Harnett County Government Complex
307 Cornelius Harnett Boulevard
Lillington, NC 27546

**Re: Status of Improvement Permit Application #05-5-12663 Lt 68 Forest Oaks
#05-5-12659 Lt 64 Forest Oaks**

On July 29, 2005, an Environmental Health Specialist from the Harnett County Health Department attempted to evaluate your property for the purpose of issuing an Improvement Permit. This individual was unable to evaluate your property for one or more of the following reasons.

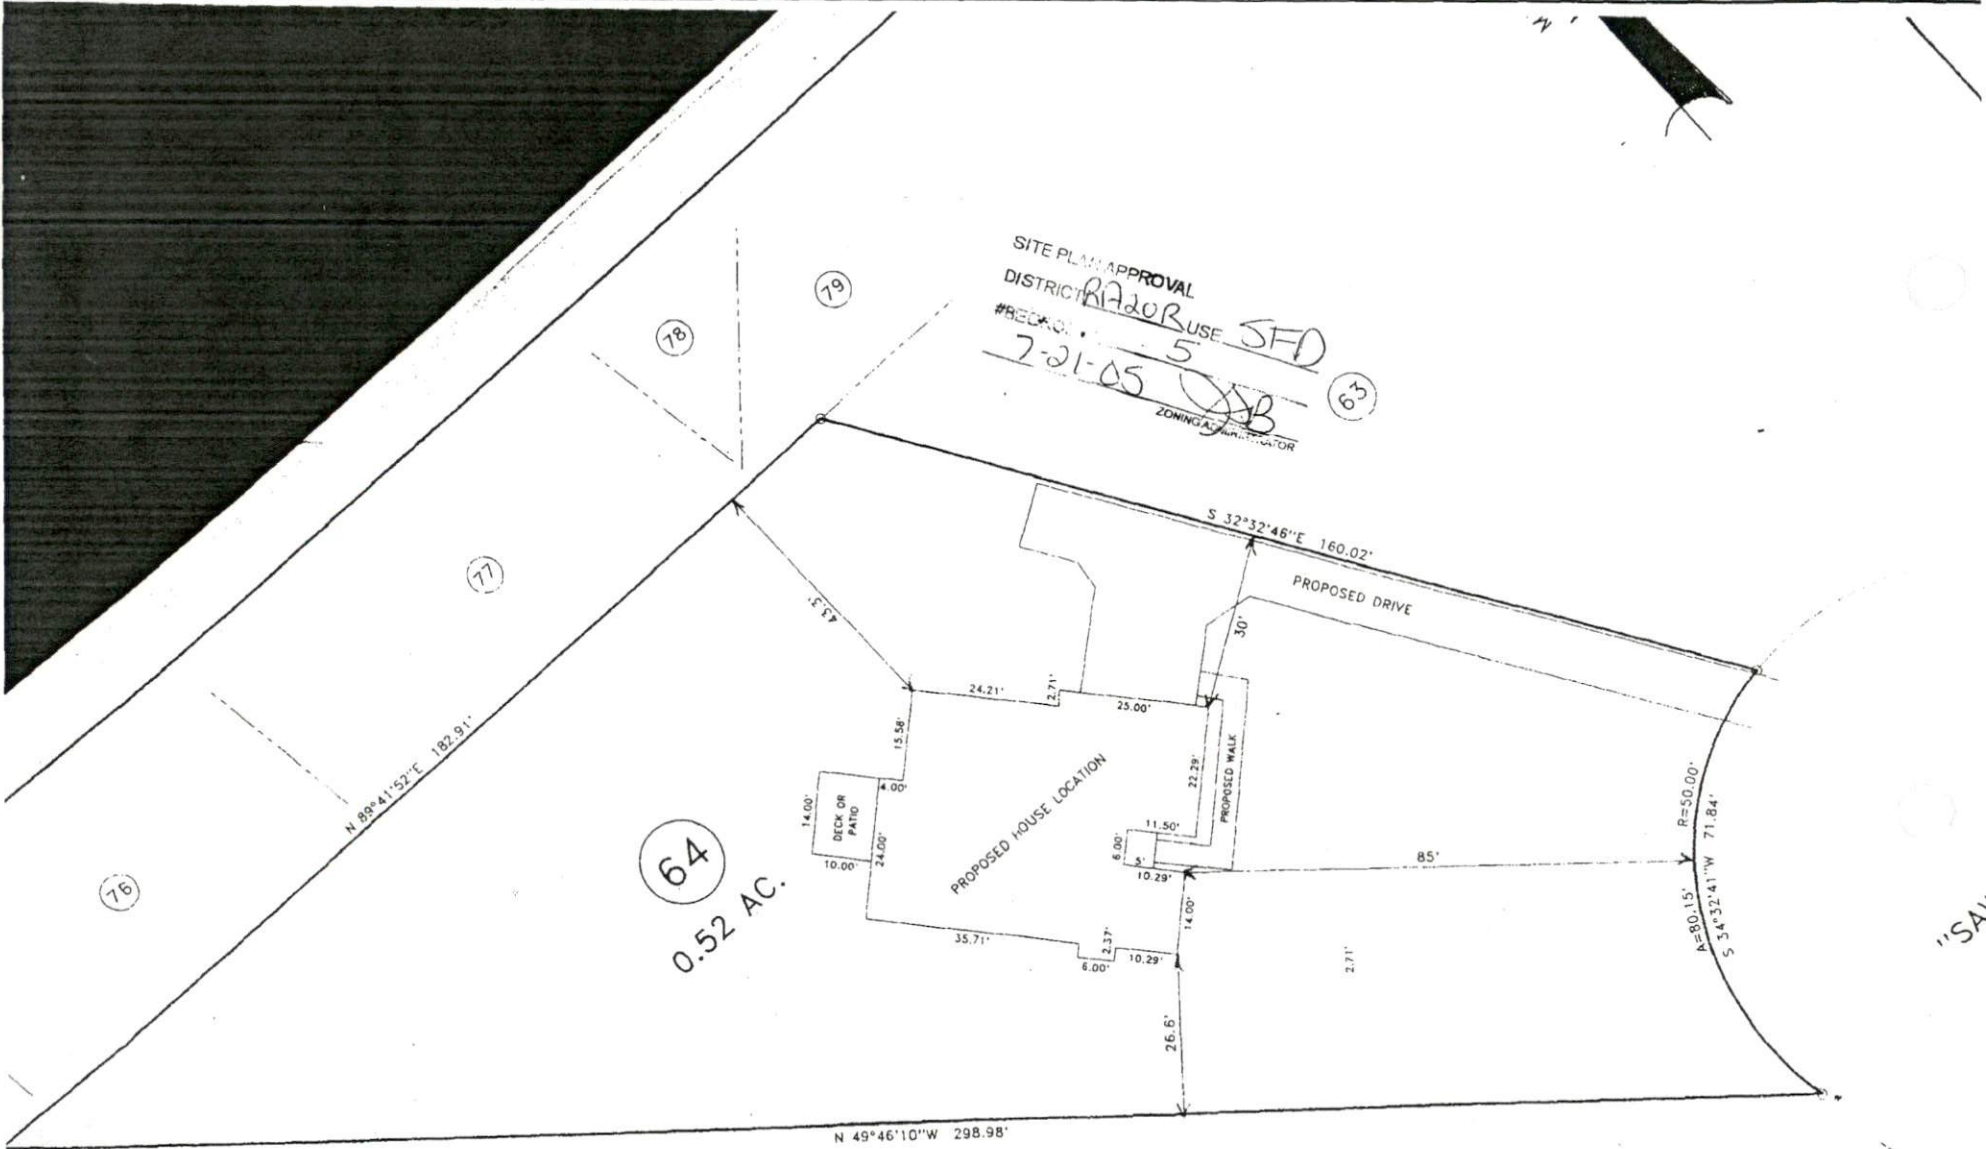
- 1. Property lines/corners not marked or labeled
- 2. House corners not marked or labeled
- 3. Directions not clear to property
- 4. Property needs brush or vegetation removed
- 5. Backhoe pits required
- 6. Other **Your consultant has sent in a plot plan & system design for a 3 bedroom home. Your application is for 5 bedrooms. Please resubmit application as a revision to Central Permitting to match your consultant work or have consultant design for 5 bedrooms.**
